## SUBMISSION 2: SUMMARY OF ADDITIONAL CONCERNS IN RELATION TO THE PROPOSED NORTHCONNEX TUNNEL

Application number - SSI 13\_6136

**This is an objection to many aspects of the proposed NorthConnex tunnel.**

MOTORWAY OPERATIONS COMPLEX - SOUTHERN VENTILATION FACILITY - SITE SECTION 1-1
M1-M2-5000-DR-UD-0713

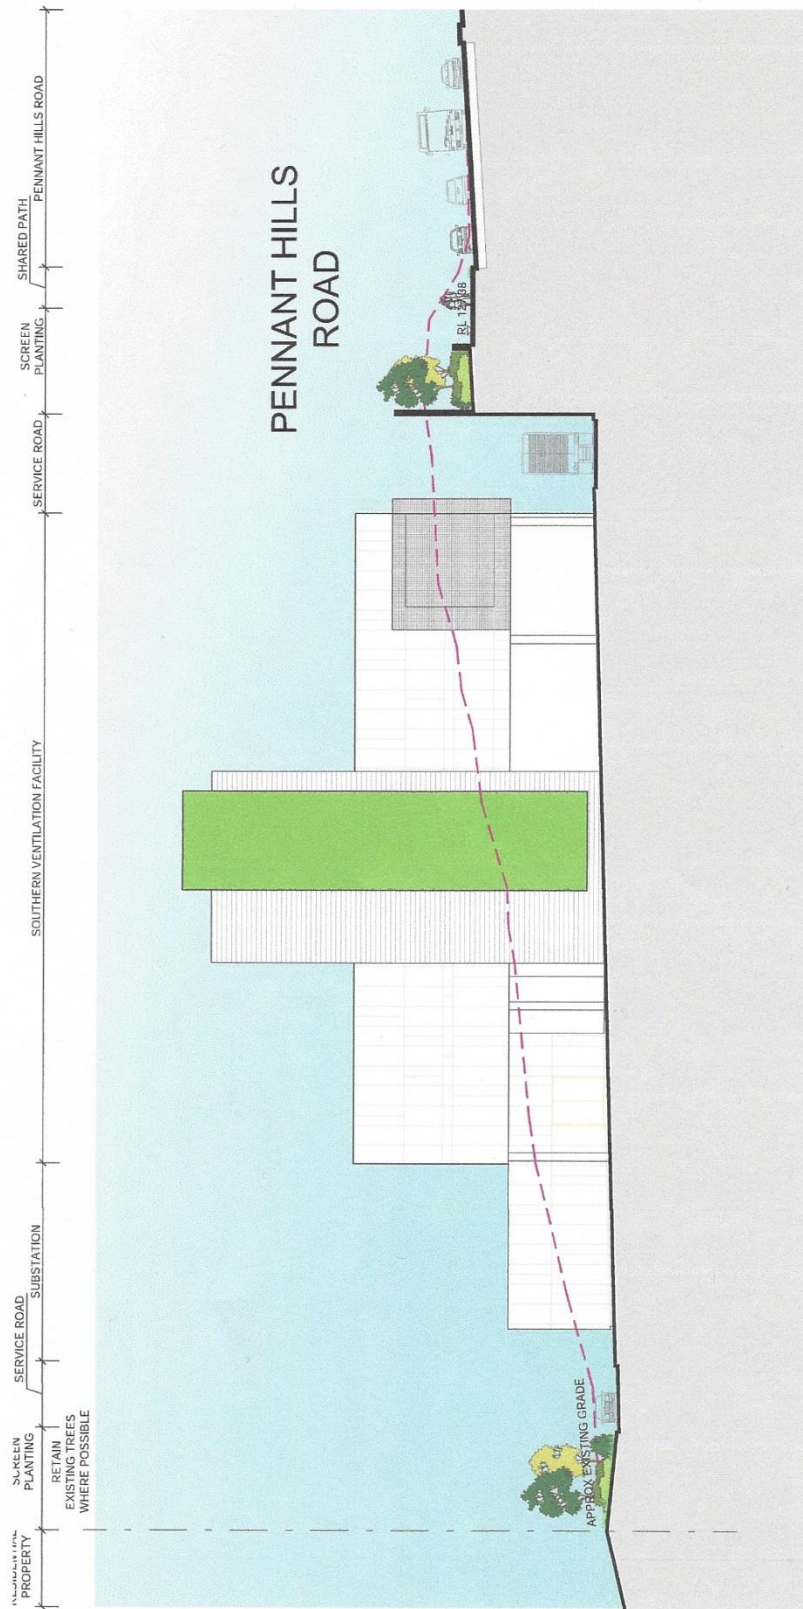
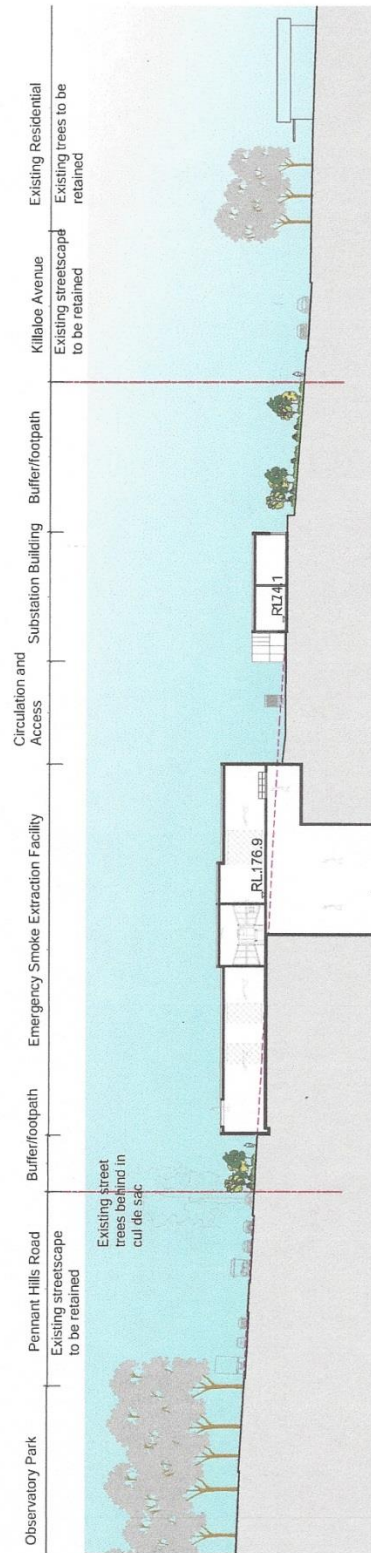
Speakers at the NorthConnex Air Quality Forum spoke of the importance of the topography in the placement of the ventilation facilities. In the NorthConnex proposal the southern ventilation facility is at the lowest point of the M2 intersection where it is surrounded on three sides by hillside cuttings. In this location the “discharge point” will barely be above the adjacent high ground.

Much is made of the intention to discharge the polluted air through the stack at 13 – 19m/s. Given that the stack is only 15m above Pennant Hills Road, a simple calculation indicates that the particles will be ejected to a height of between 23m and 33m above Pennant Hills Road. That will only be sufficient for them to be dispersed by prevailing winds IF there is wind and it is strong enough. For instance, the weather history graph showing the wind speed and direction at West Pennant Hills measured on the 24th August 2014 indicated that there was no wind until 9am and what wind there was, came from the west. Wind speeds of less than 2m/sec (ie about 8km/hour) are not considered sufficient to disperse pollution from the stack. Only a very few gusts on this day were in excess of 8km/hour.

That the Government ensures that the southbound ventilation facility ie the Stack, be located at the south-west corner, on the RMS owned land, at the edge of the Pennant Hills Golf course. In this location, the southbound tunnel can be efficiently, effectively and economically ventilated.

The impact of the stack plumes on the surrounding residential areas must be modelled using its current proposed position and height and also modelled with the stack positioned on the golf course side of Pennant Hills Road, where it is topographically higher. This would allow an objective, impartial, scientifically based assessment to be made of the most effective location for the stack.
